CITY OF ALBUQUERQUE

**RE: Albuquerque Ranch Estates
12500 Bevan Way NE
Permanent C.O. – Accepted
Engineer's Certification Date: No Date
Engineer's Stamp Date: 04/21/22
Hydrology File: E22D002J**

Based on the information in your submittal received 08/17/2025, Engineering Certification is not approved for Permanent CO.

Grading and Drainage Plan-COO Submittal

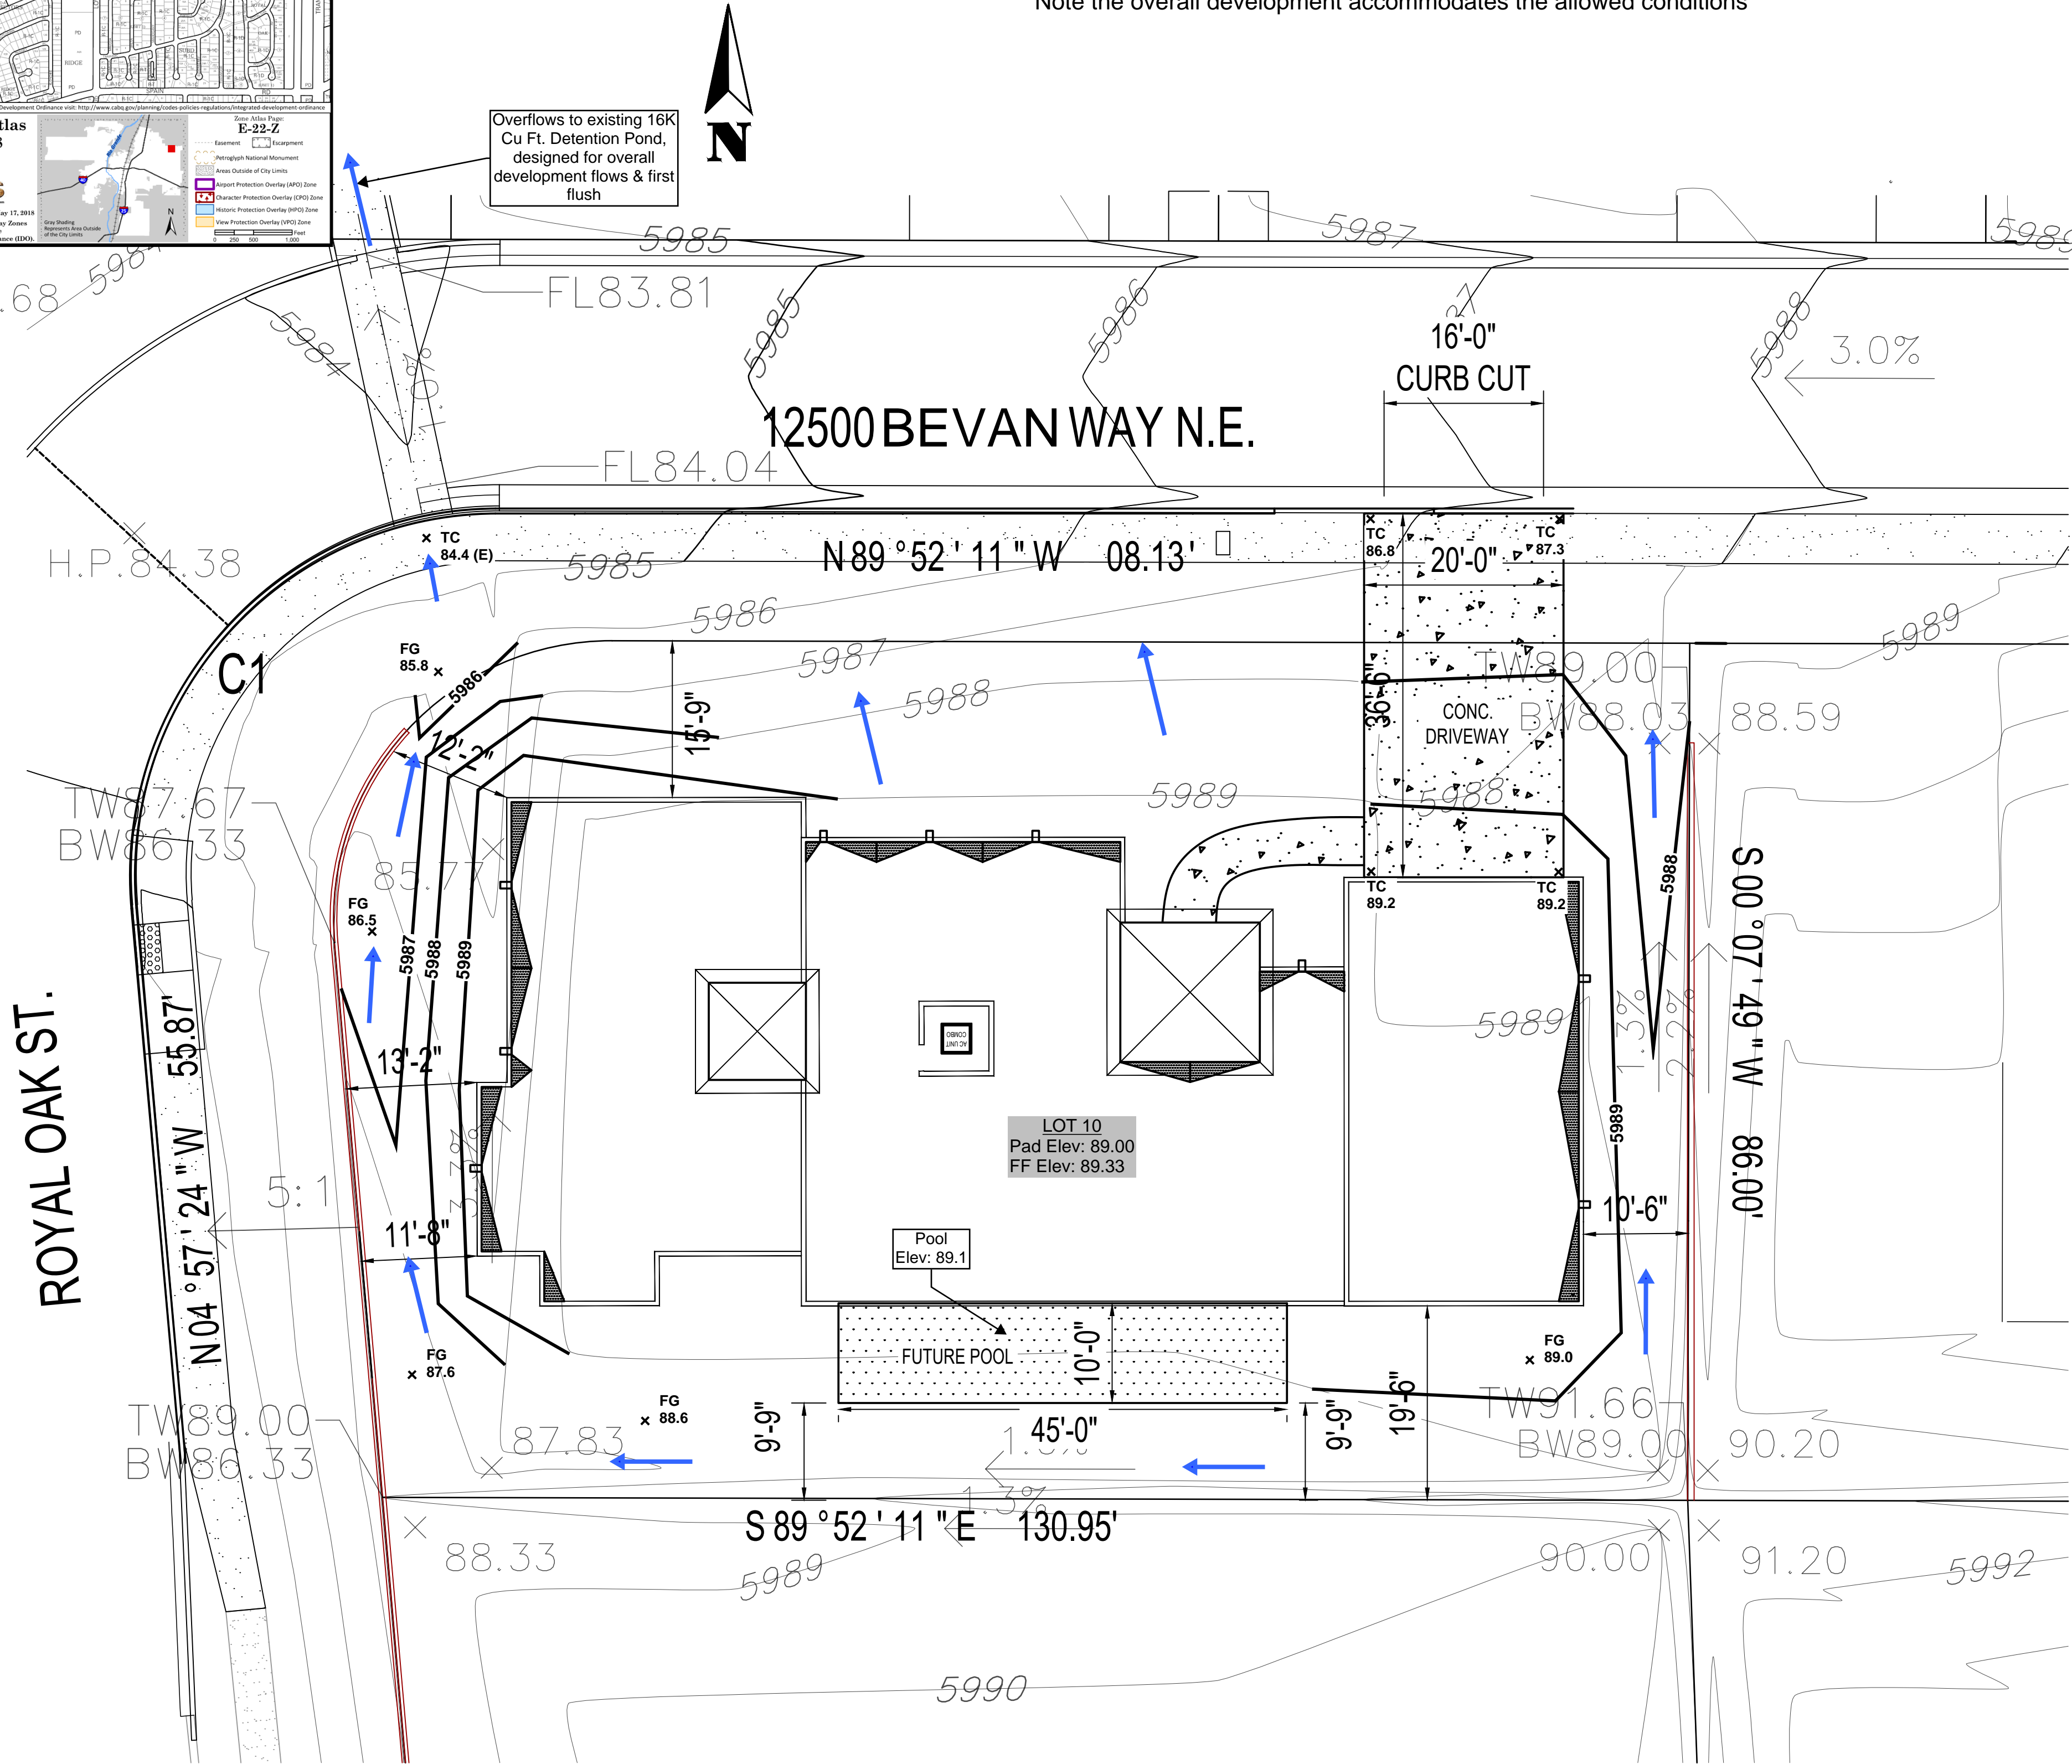
The following comments need to be addressed for approval of the above referenced project:
1. Per the DPM Part 6-14(H), please add the Required Certification Language to the plan and re-submit.
